| Application number: 2024/93428   |                                                                                  |
| What is the application for?:    | Demolition of existing conservatory and erection of replacement single storey re |
| Address of the site or building: | 18, Templar Drive, Almondbury, Huddersfield, HD5 8HS                             |

Ground Floor Plan
as Proposed

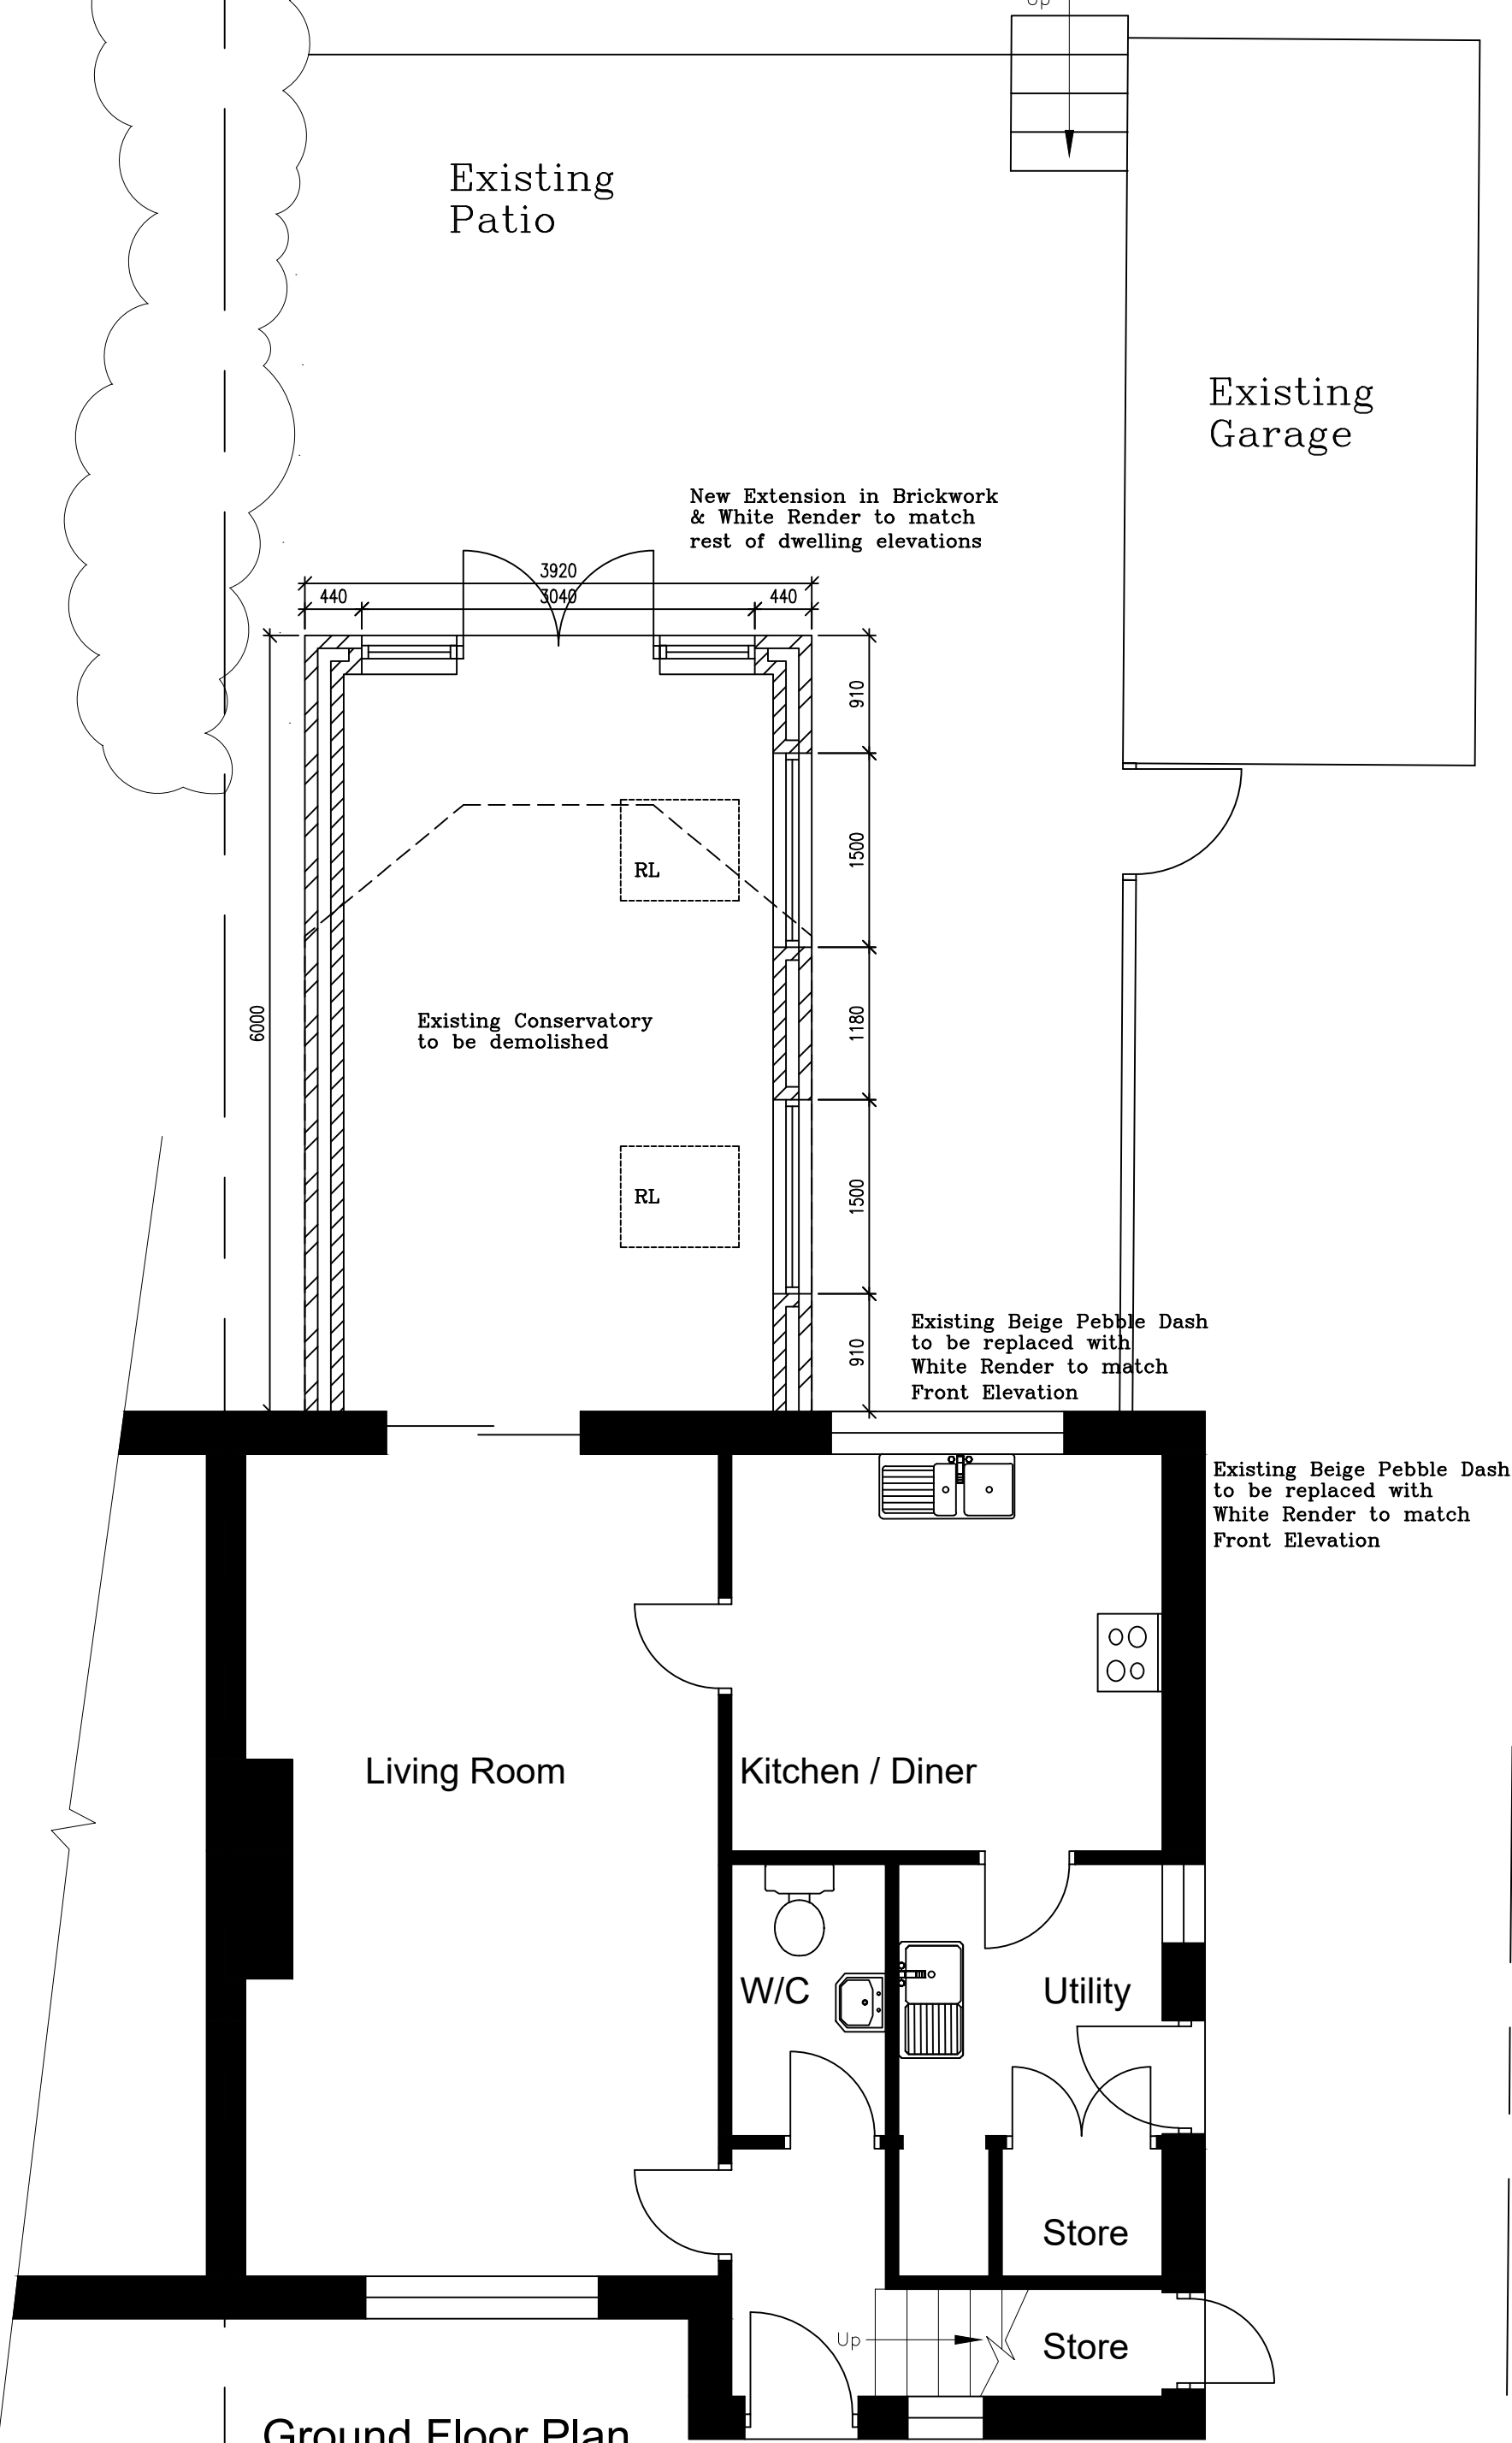
| <p>Planning Application number 2024/93428</p> <p>18, Templar Drive, Almondbury, Huddersfield HD5 8HS</p> <p>Demolition of existing conservatory and erection of replacement single storey rear extension with associated external alterations</p> <p>I, , of 20 Templar Drive, Almondbury, on the 29/12/2024, formally object to the planned extension to 18 Templar Drive on the following grounds:</p> <p>Access to sunlight which crosses from the right-hand side.</p> <p>Sunlight crosses from the right of property number 18, directly on to our garden. The right to light onto our garden is non-negotiable.</p> <p>Potential damage to the conifer hedge, crossing the boundary of the two properties. Presently there are birds that nest in the conifer hedge. To disturb the conifer hedge would be to interfere with their natural habitat. The conifer hedges are our responsibility and belong to us. Any interference or proposed dismantling of the conifer hedge which was planted over thirty years ago would be against our wishes.</p> <p>Disruption caused by building an exterior extension in close proximity to our property at number 20.</p> <p>Our household insurance company reassured us that any damage caused by the proposed building will have to be paid for by the neighbours, or builder. This includes any damage to our property, caused by the building works, including any serious damage: such as digging below our foundations; to lesser but still problematic issues caused, such as: dirt and dust from demolition of the existing conservatory and building the new extension, which will inevitably cross onto our side due to the proximity of our properties.</p> <p>As, my home is painted white, with white render on all our exterior building walls this could potentially involve the back of the home needing to be repainted. The rear exterior building walls to home was repainted only recently, so this would be a timely and unnecessary inconvenience to ourselves, for which we would see none of the benefit of having to redo the wall again.</p> |    |

Previously we had an informal agreement between former neighbours and ourselves with regards to drainage from their property onto our garden rockery. Due to the logistics of the construction of the conservatory at number 18, it was necessary to have a pipe that drained water from our neighbours onto our garden. As this informal agreement was agreed upon with our former neighbours, any new building works will have to rectify this and deal with the issue on their own property. This agreement is with our former neighbours and not our new ones.
